From: White, Joy - Communities
Sent: 17 July 2020 17:16
To: Matthew Chadwick <Matthew.Chadwick@Cherwell-DC.gov.uk>
Cc: Planning <Planning@Cherwell-DC.gov.uk>; Cllr George Reynolds <George.Reynolds@Oxfordshire.gov.uk>
Subject: 20/01523/DISC - Manor Road, Great Bourton OX17 1QT

TITLE:
Construction Plan

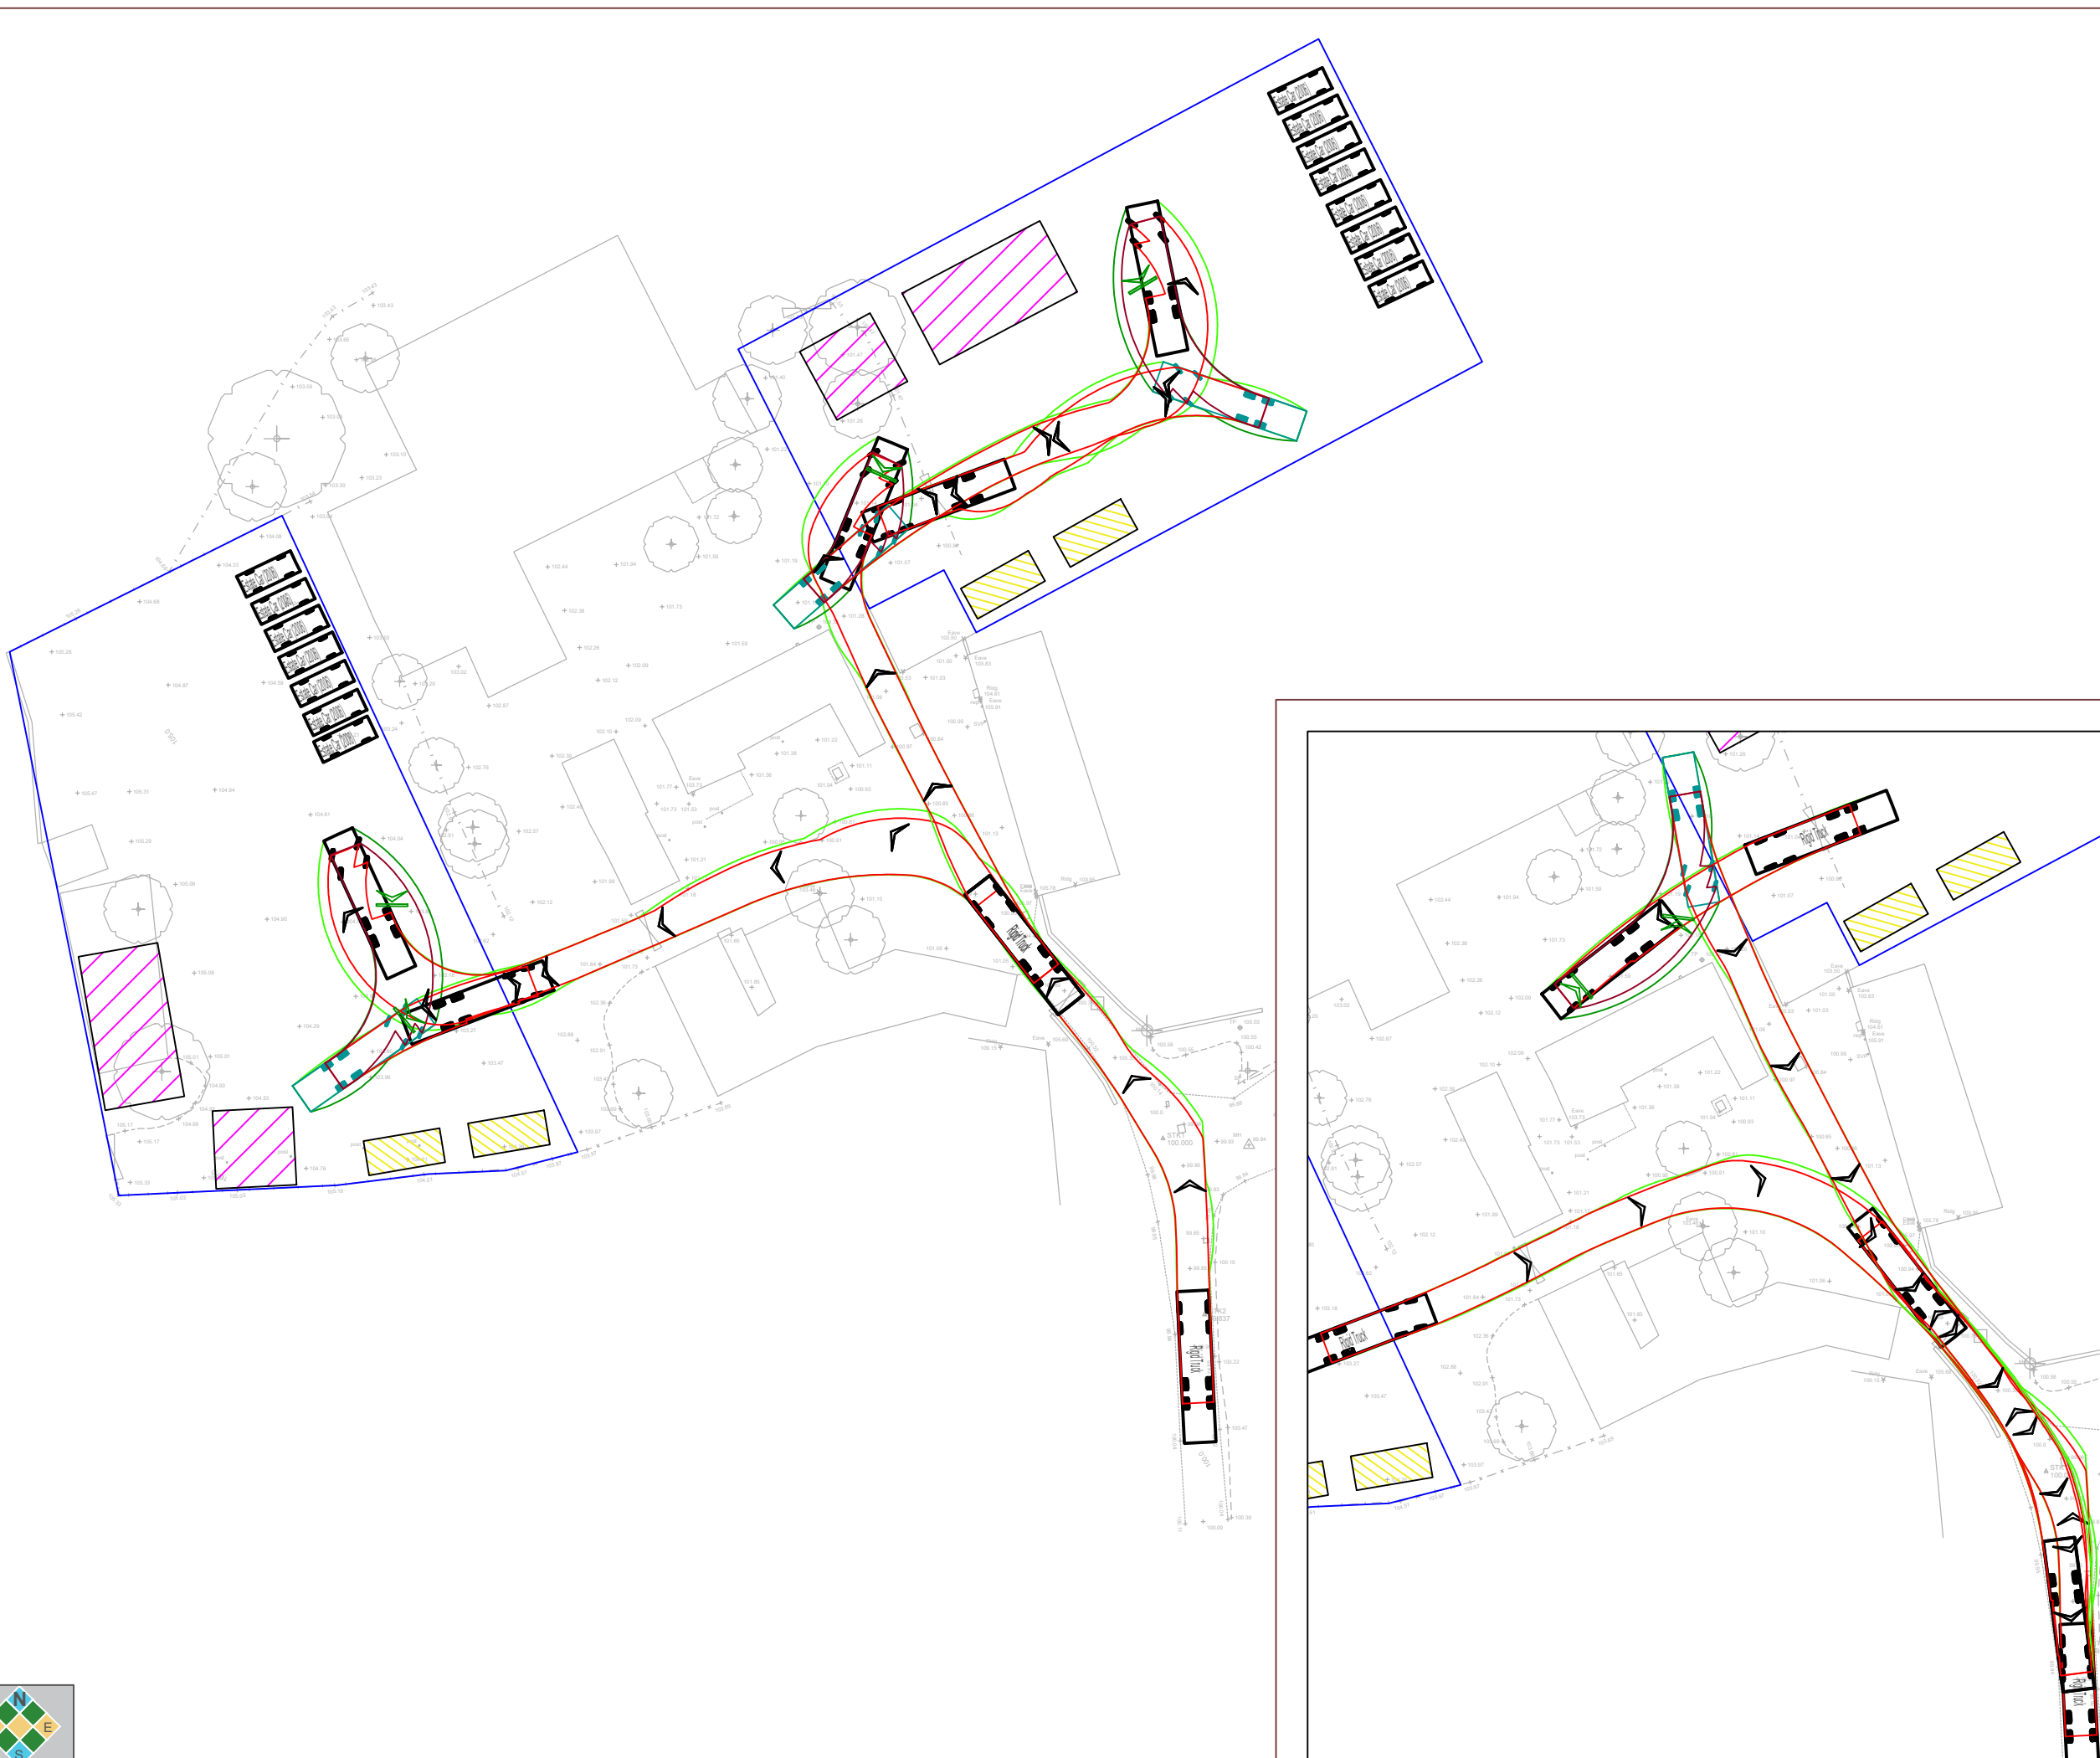
I have reviewed the construction traffic management plan and given the constrained nature of the road network in this area, as well as the potential for construction traffic to cause a nuisance and a potential safety risk, we would like to see commitments included in the CTMP to the effect that:

1. All construction delivery and waste removal vehicles will approach and leave from the West (Southam Road)
2. The proposed waiting area to the east of the site will not be used.
3. Due to the poor visibility at the junction of Manor Road, banksmen will guide all HGVs leaving the site along and out of Manor Road. Contractors and site workers must be warned to take particular care at this junction.

TITLE:  
**Proposed Internal Access  
Works - Finishes, Kerbing and  
Levels**

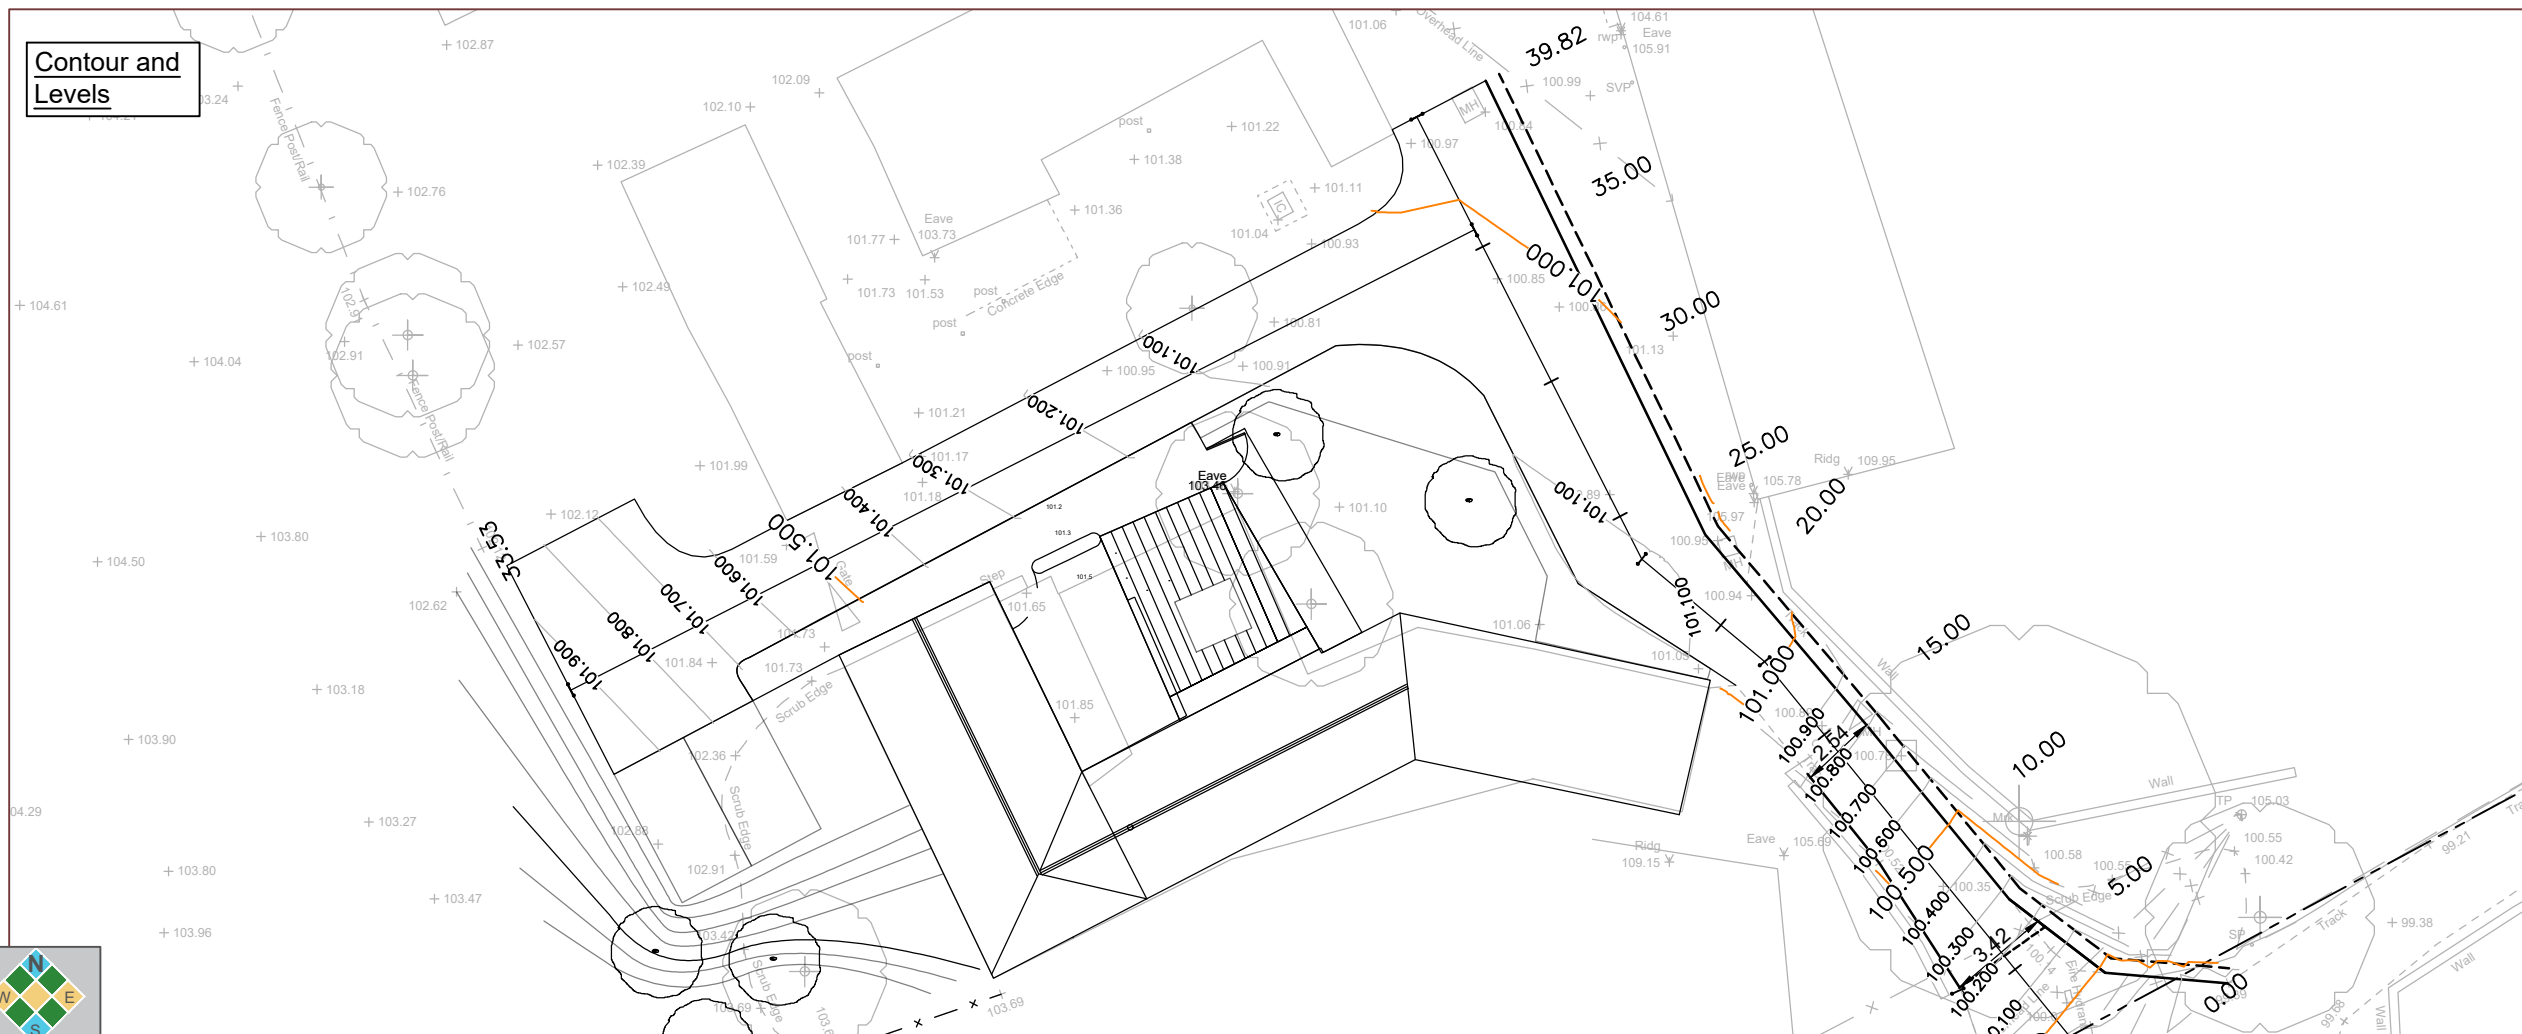
The access junction proposals are acceptable, but will require the developer to enter into an agreement with OCC under S278 of the Highways Act 1980 prior to any works on the highway. Additional detail will be required with the S278 submission - details of what will be required can be found on OCC's website:
